# **City of Albuquerque**

**Planning Department  
Transportation Development Services Section**

March 9, 2004

Re: Certification Submittal for Final Building Certificate of Occupancy for  
Grandma's Music & Sound, [C-13 / D25B]  
9310 Coors NW  
Architect's Stamp Dated 03/08/04

GRADING, DRAINAGE & UTILITY PLAN

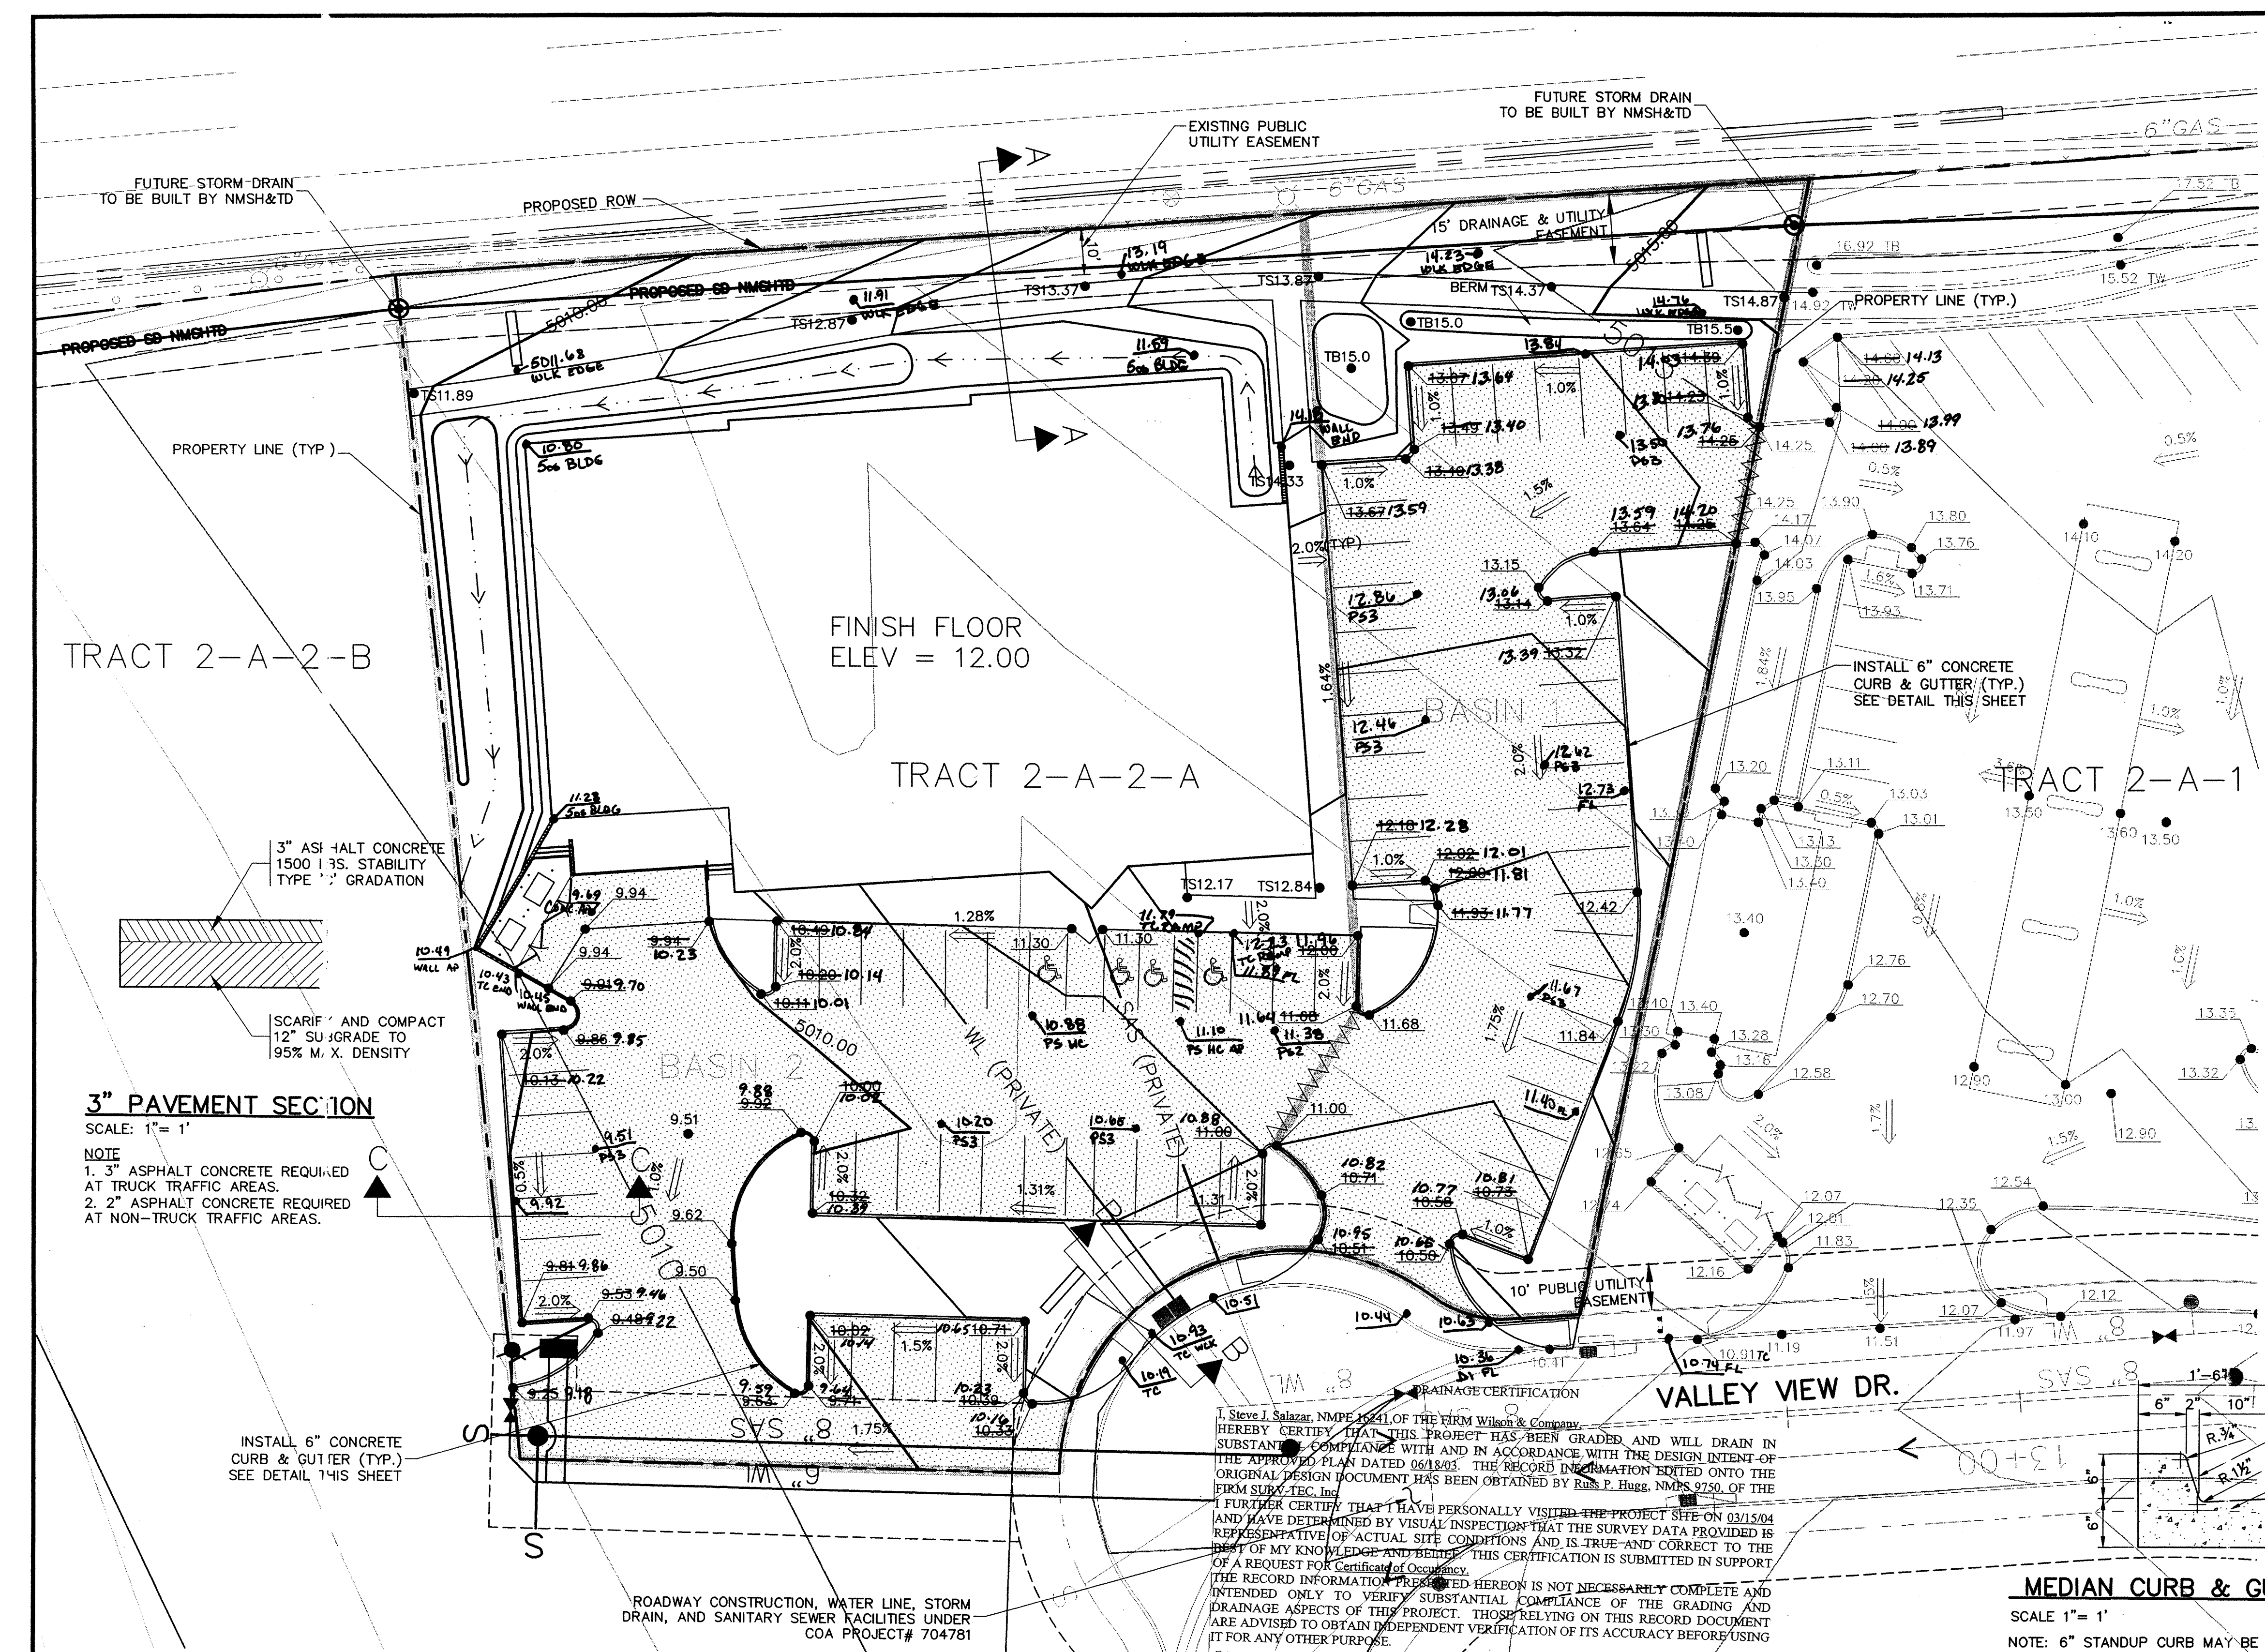
**Comment 1:** A drainage easement is required for cross-lot drainage through Tract 2-A-2-B.

**Comment 2:** Please address erosion control due to cross-lot drainage.

**Comment 3:** Please show storm drain on west side of property.

1. A drainage easement is required for cross-lot drainage through Tract 2-A-2-B.
2. Please address erosion control due to cross-lot drainage.
3. Please show storm drain on west side of property.

**Solution:** A drainage easement shall be granted through the plat: Tracts 2-A-2-A, 2-A-2-B and 2-A-2-C Black Ranch. The following language will be included in the plat (Also see attached).

A "Private Drainage Easement" covering Tracts 2-A-2-A, 2-A-2-B, and 2-A-2-C (Excepting therefrom any buildings) is hereby granted by this plat. Said Easement is required to accept sheet flows from said located on the East Side of Tract 2-A-2-C. Maintenance of said easement to be the responsibility of each respective owner. (As to each Tract).

**Solution:** The cross-lot drainage shall drain into a temporary *desilting* pond located at the southeastern portion of tract 2-A-2-C. A desilting structure is located in this pond which will drain into the AMAFCA detention pond in Tract 2-B. The *desilting* pond shall be maintained by the property owner as per the approved Drainage Master Plan for Black Ranch Tracts 2 & 3, dated December 2002.

**Solution:** The proposed storm drain system is shown on plan. This system is to be built by the NMSH&TD.
